Planning Services Sign Permit Review Form

Date of Submittal	Application Number	Applicant	Landowner
3/10/2022	SIGN2203-0005	Signs of the Pines, Inc.	MDC NC3 LP

Contact Person	Jonathon Walter	Contact Number	910-691-3000
Sign Location	E. side of the property, currently proposed in the ROW	PIN Number	9584-89-3061.000

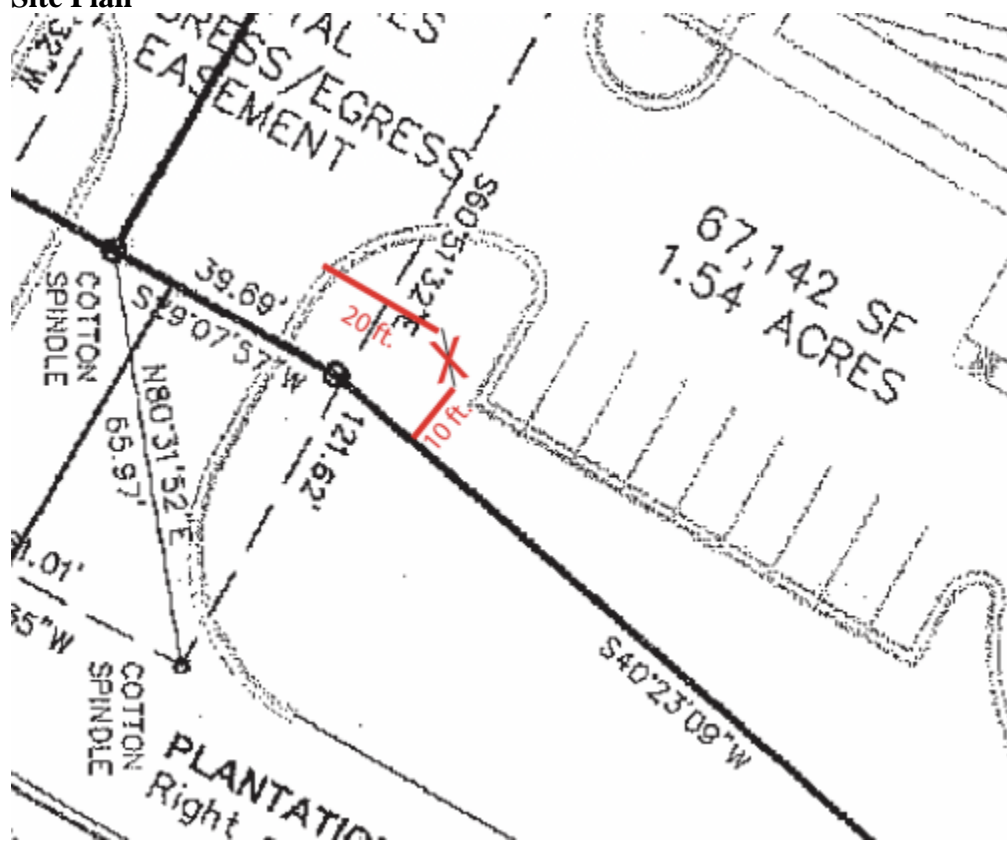
Comments	The sign is proposed in the ROW. Sign must be setback a minimum 10' from the ROW, not edge of pavement.
----------	---
